Arun District Conservation Area Advisory Panel
c/o Civic Centre

9th December 2020

Application No: AB/118/20/PL
Site Address: 70A Tarrant Street Arundel BN18 9DN
Description of works: Extension to form 2 No. self contained apartments. This application may affect the setting of listed buildings, affects the character & appearance of the Arundel Conservation Area & is in CIL Zone 2 & is CIL Liable.

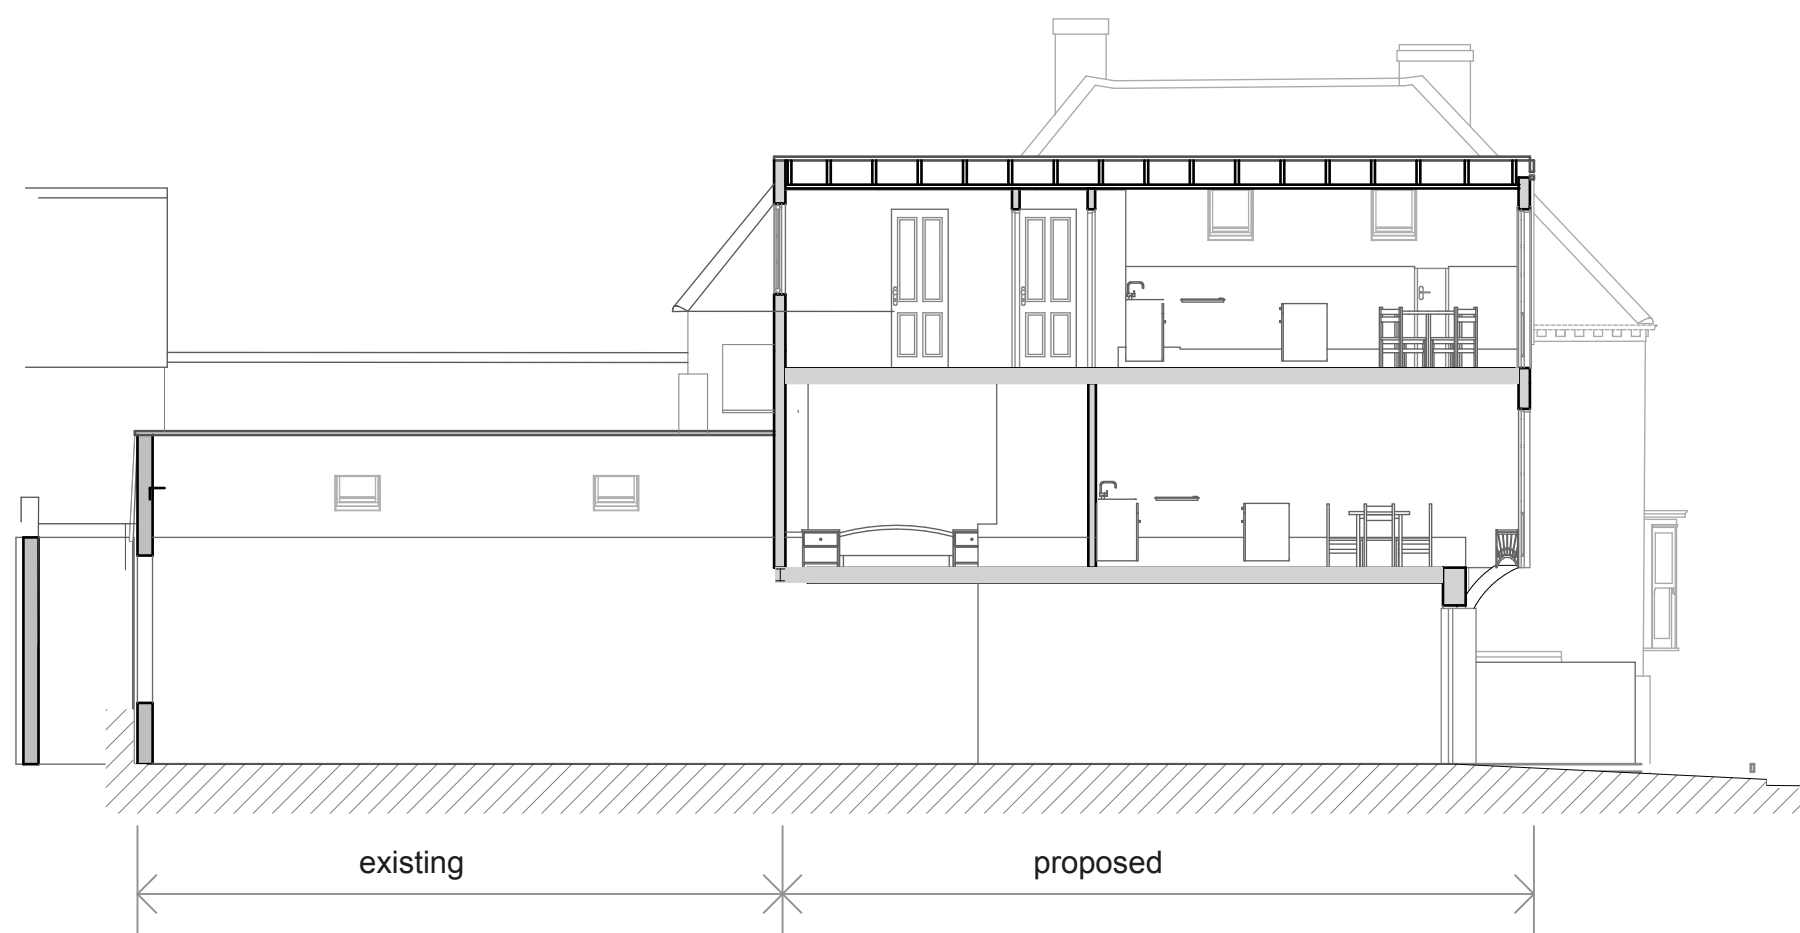
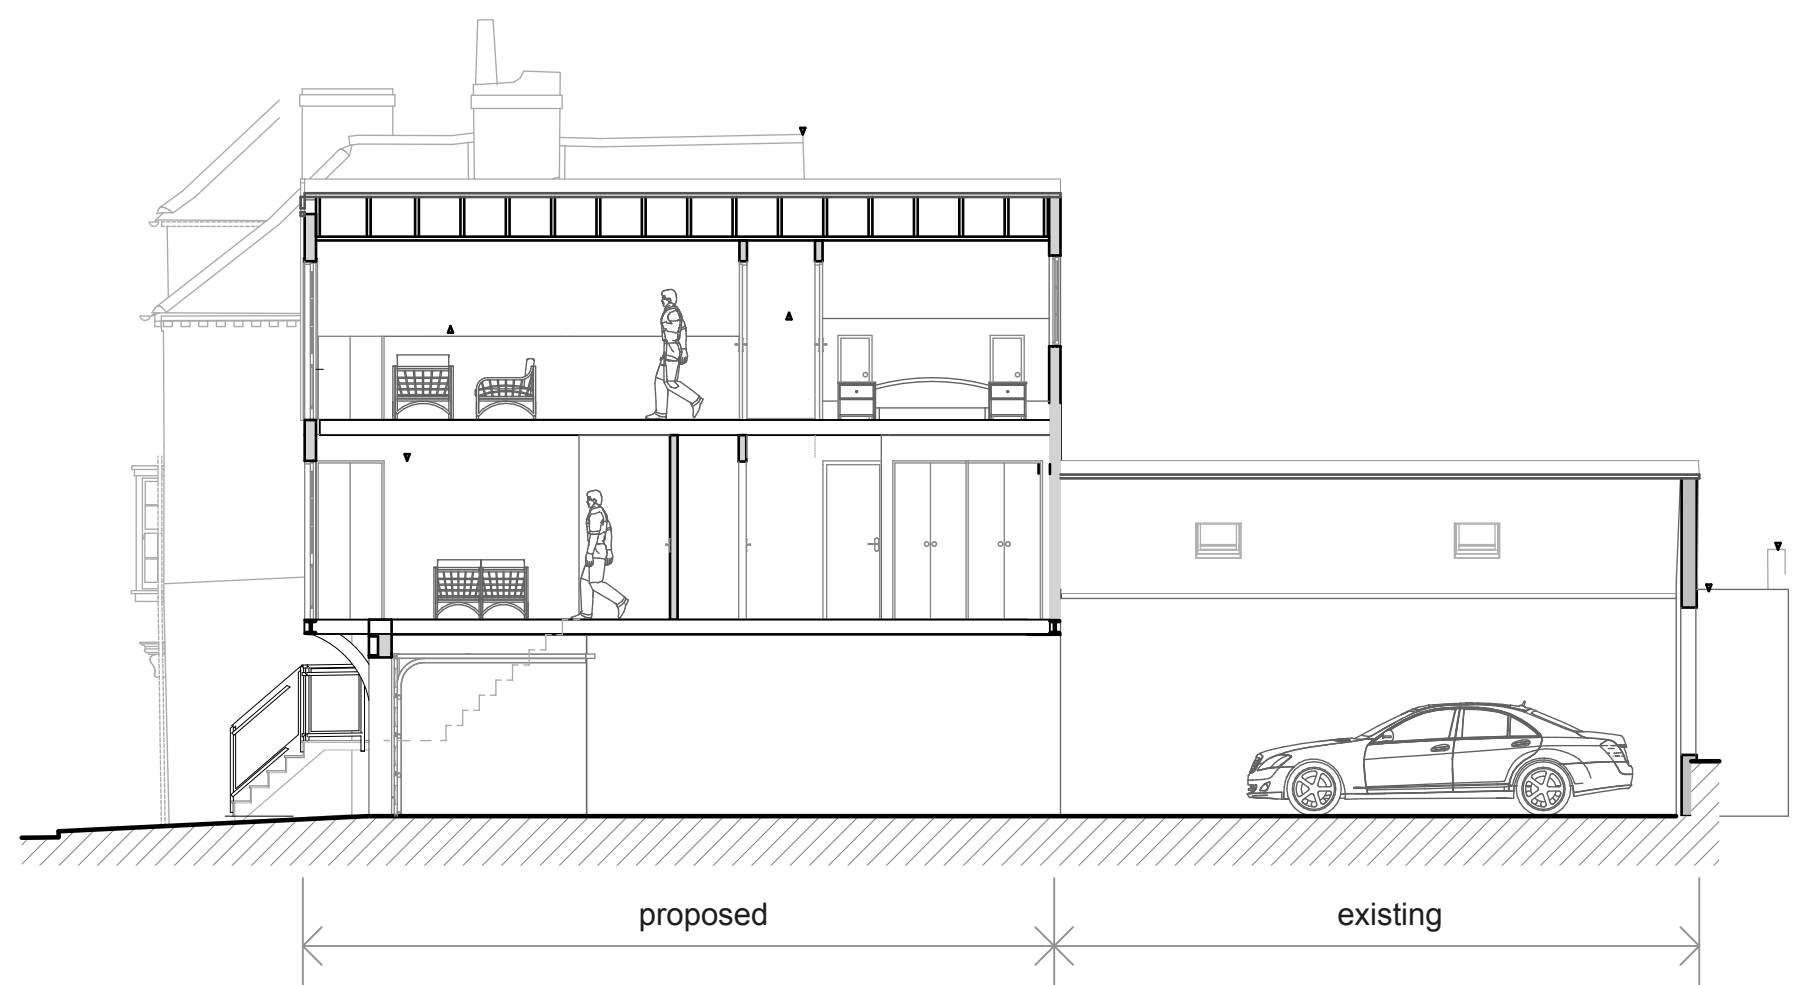
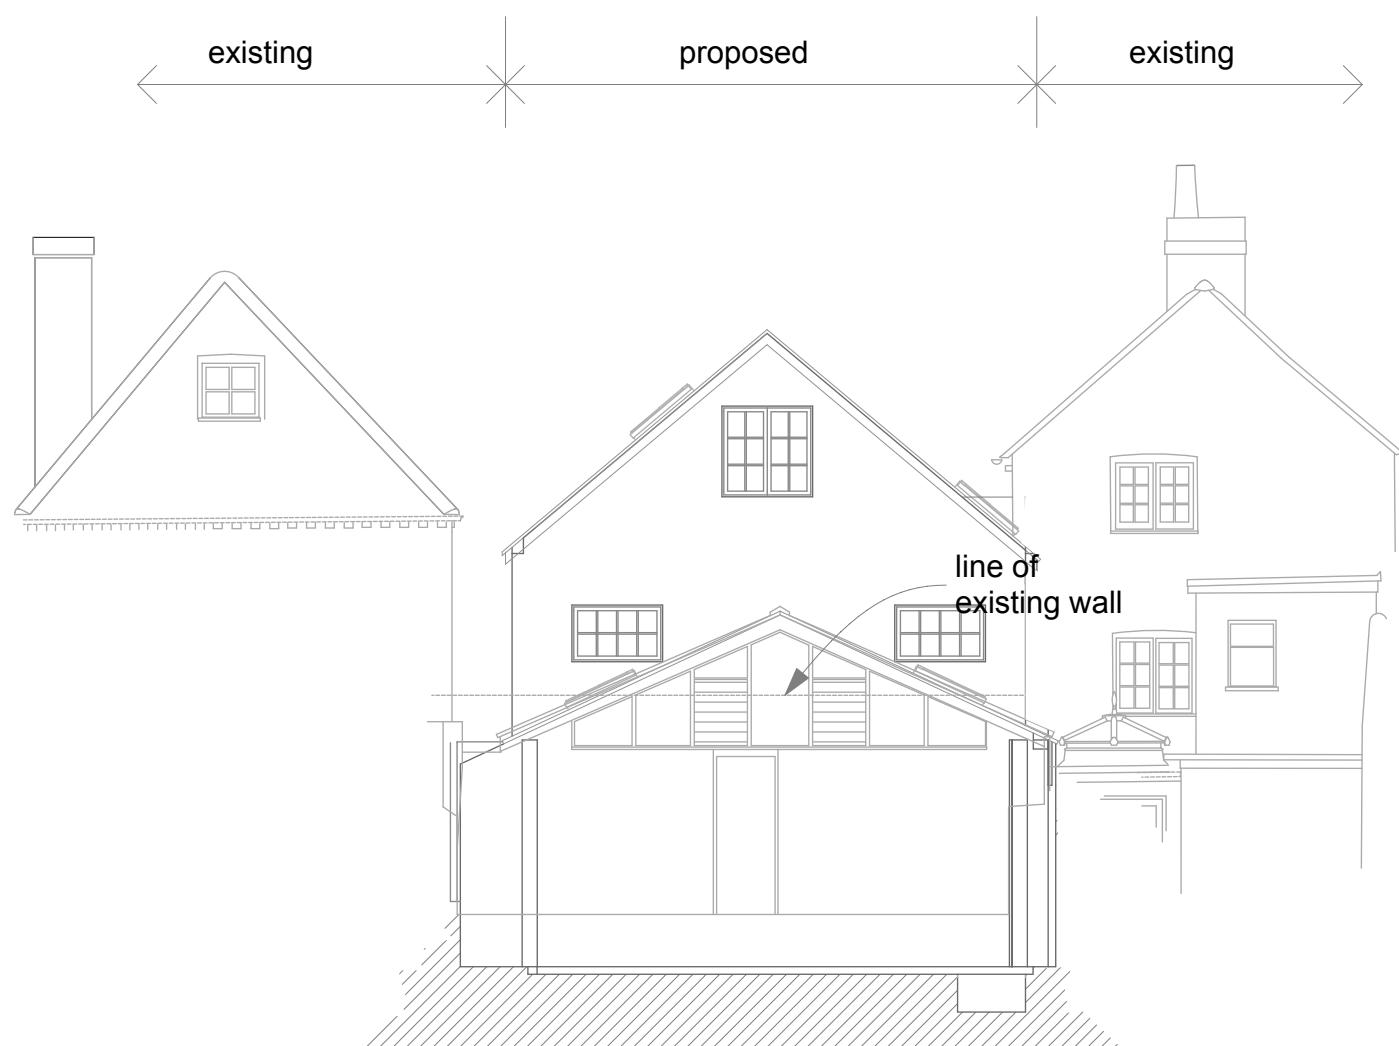
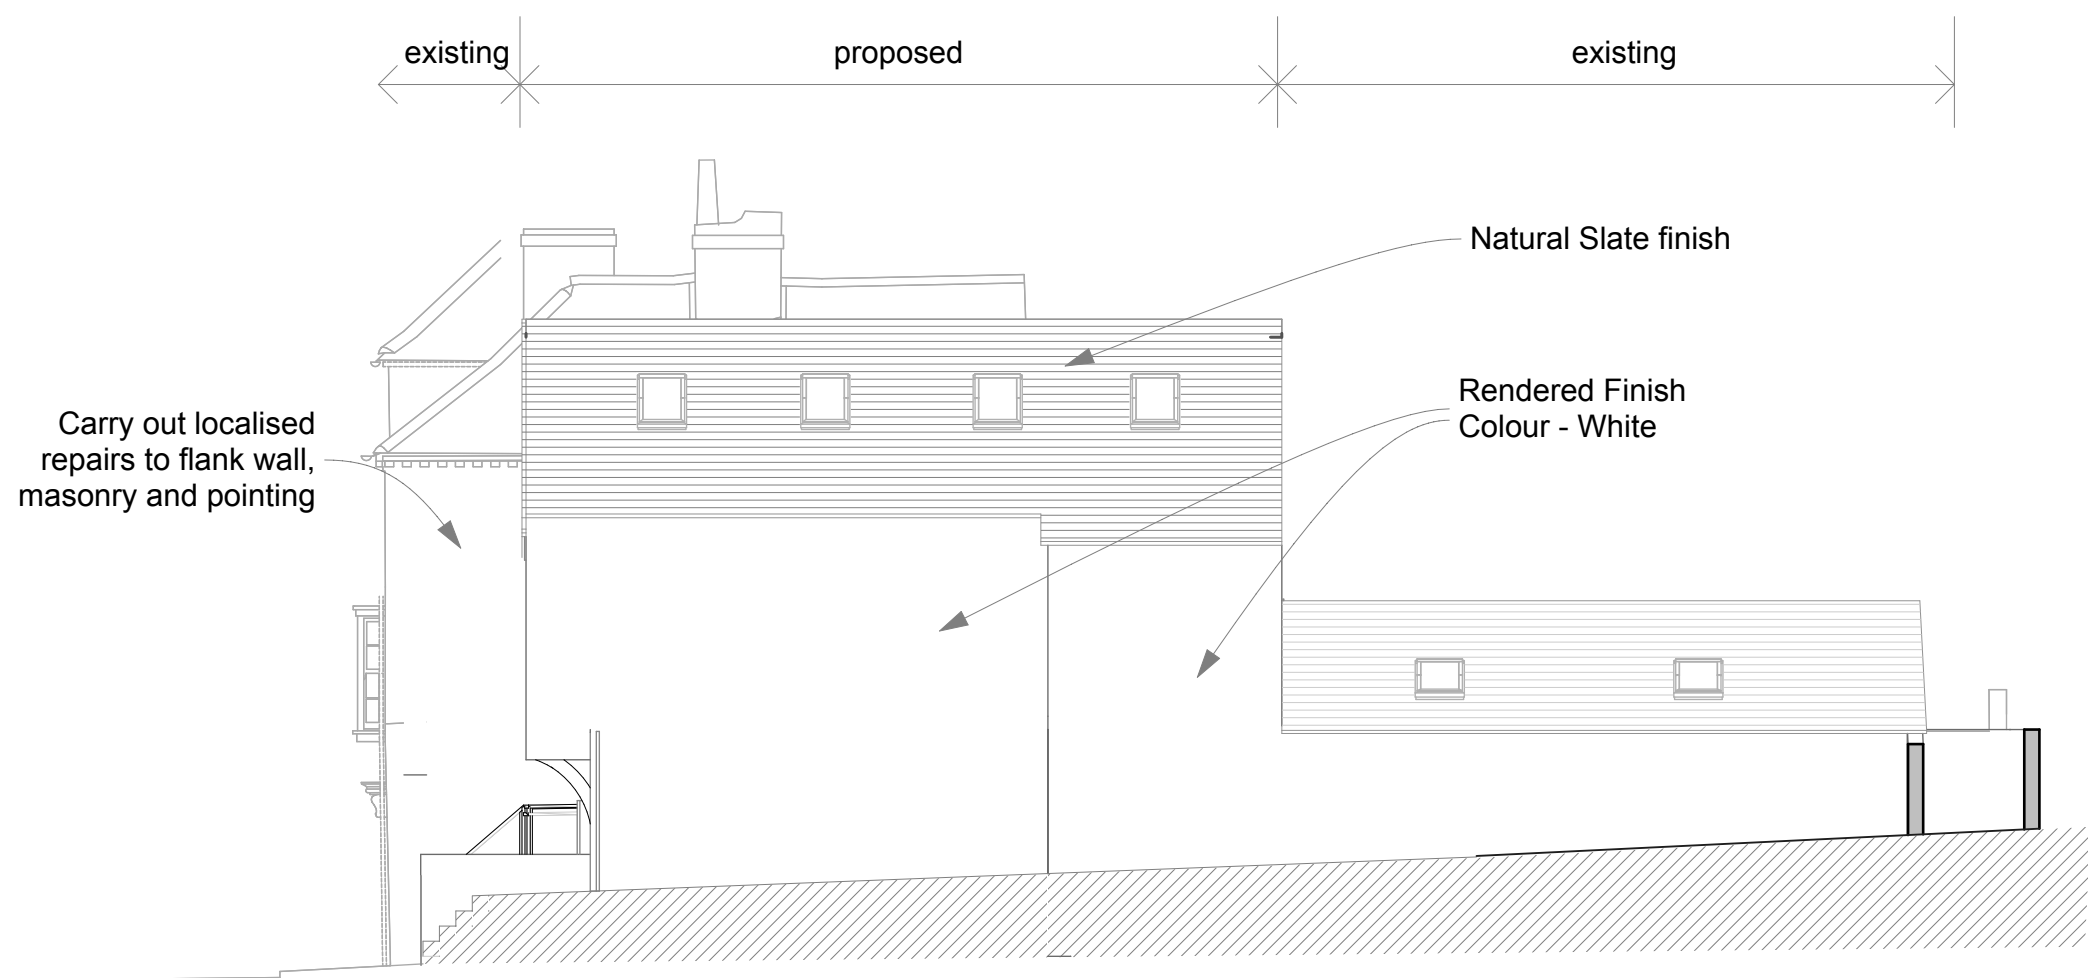
The success and appropriateness of the scheme will depend totally on the quality of finishes, materials and detailing. As such it is strongly recommended that conditions be attached to any planning permission granted requiring the submission of:

- (1) Precise details of fenestration, including materials, operating mechanism and setback from the front face of external walling.
- (2) Samples of the timber cladding, new external brickwork, and the natural slates for the roof of the building.
- (3) Precise details of the bargeboards and eaves.
- (4) Precise details of the external staircase and balustrading shown provided to the street elevation of the building.
- (5) All new rooflights need to be conservation style.
